Reference No:	2023/62/92739/E
Site Address:	57, Nab Lane, Mirfield, WF14 9QH
Description:	Demolition of existing garage and erection of two storey side extension, single storey rear extension and dormers to front and rear
Recommending Officer:	Edward Cheseldine

Officer Report

2023/92739 - 57, Nab Lane, Mirfield, WF14 9QH

Proposed Left Side Elevation
- East

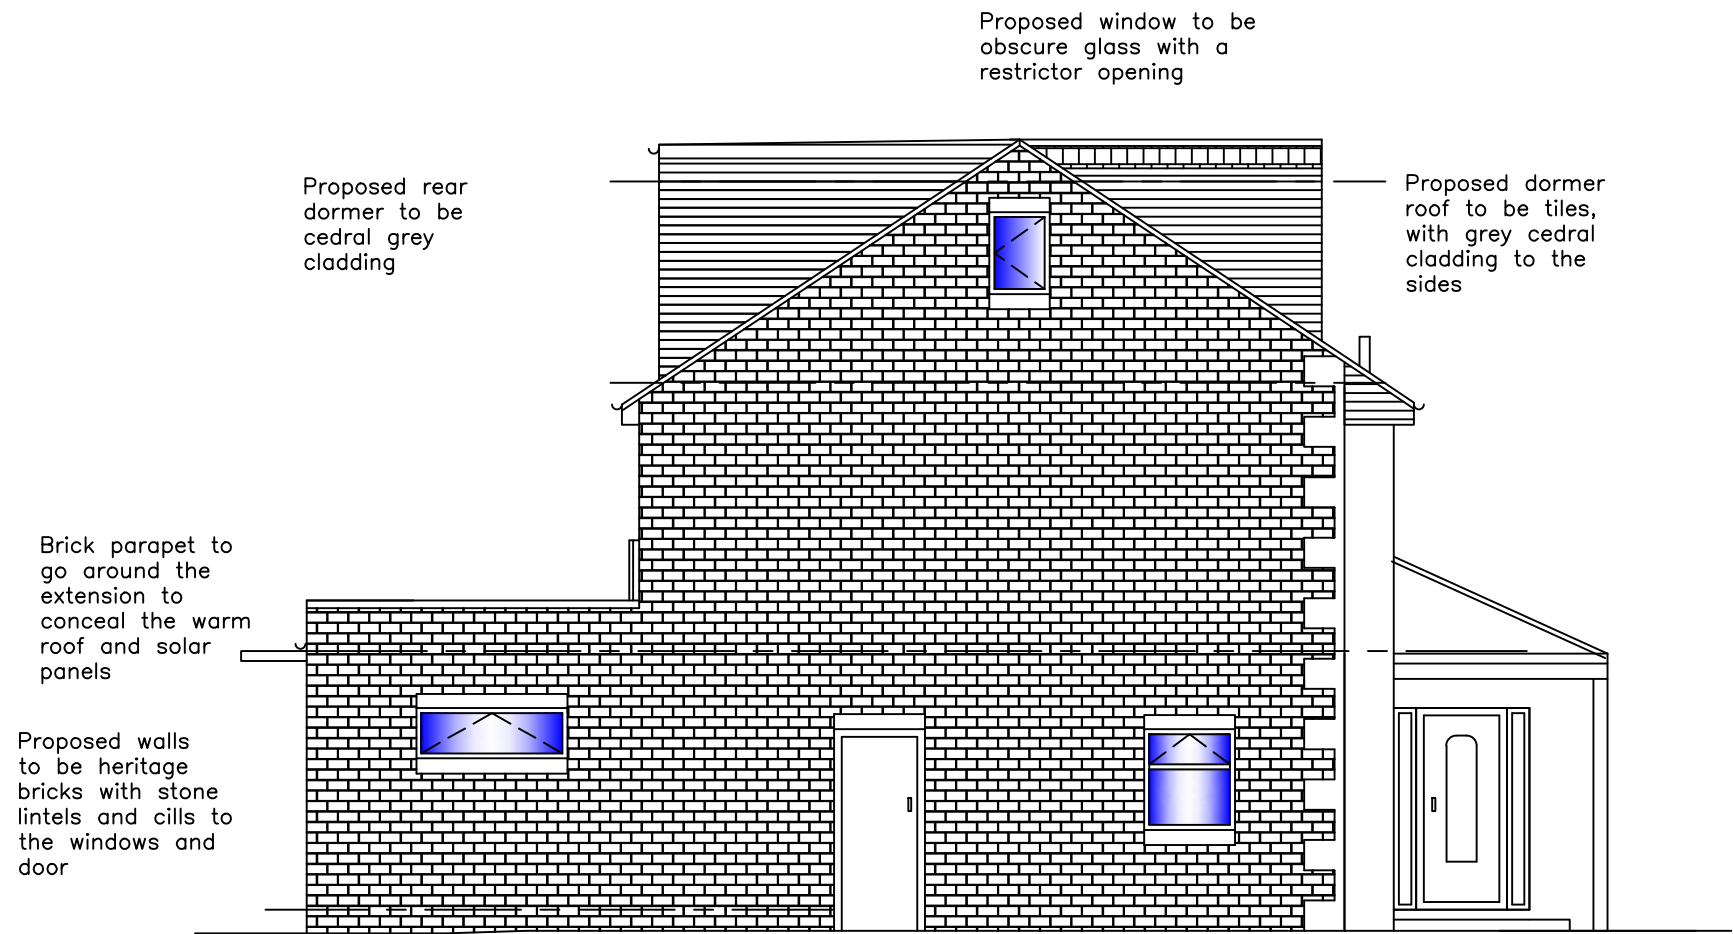
In terms of the side extension, it will be set back from the original house by 500mm and leave a side space of 1.0m to the boundary gap. Whilst these details may provide a visual break to the building, the side extension will not be set down from the ridgeline of the original building, appearing in situ with the original house. Such a large side extension will provide additional massing to the east side of the property without the visual break of the roofline. The dwelling is higher than its neighbour to the east, and due to the large, pitched roof and linear appearance, dominates the street scene. To introduce a side extension that does not appear subservient will not be proportionate or well balance which is contrary to Key Design Principle 2 of the Kirklees House Extensions & Alterations Supplementary Planning Document. Additionally, the two adjacent dwellings have benefitted from side extensions which have been set down from the original roofline and appear subservient.

In comparison to the adjacent buildings, the proposal will result in the formation of a continuous ridgeline with large facing dormers that will dominate the roof space. Such a massing is not found in the immediate vicinity, where dormers are smaller, set off the ridgeline and gutter line and leave a significant proportion of the original roof space. Additionally, side extensions are set down and back giving a definitive subservience to the original dwelling.

1. The proposed development, due to size, design, lack of setting down of the ridge, would increase the bulk and massing of the dwelling, visually appearing top-heavy, dominating the roof and side elevation of the dwelling appearing incongruous with the host building detrimental to the character and appearance. To allow the proposal would form a continuous ridgeline with large front & rear facing dormers which fails to respect the scale and design of the original dwelling and streetscape being contrary to the aims of Policy LP24 (a & c), as well as Principle 1 & 2 of the Kirklees House Extensions & Alterations SPD and the advice within Chapter 12 of the National Planning Policy Framework.
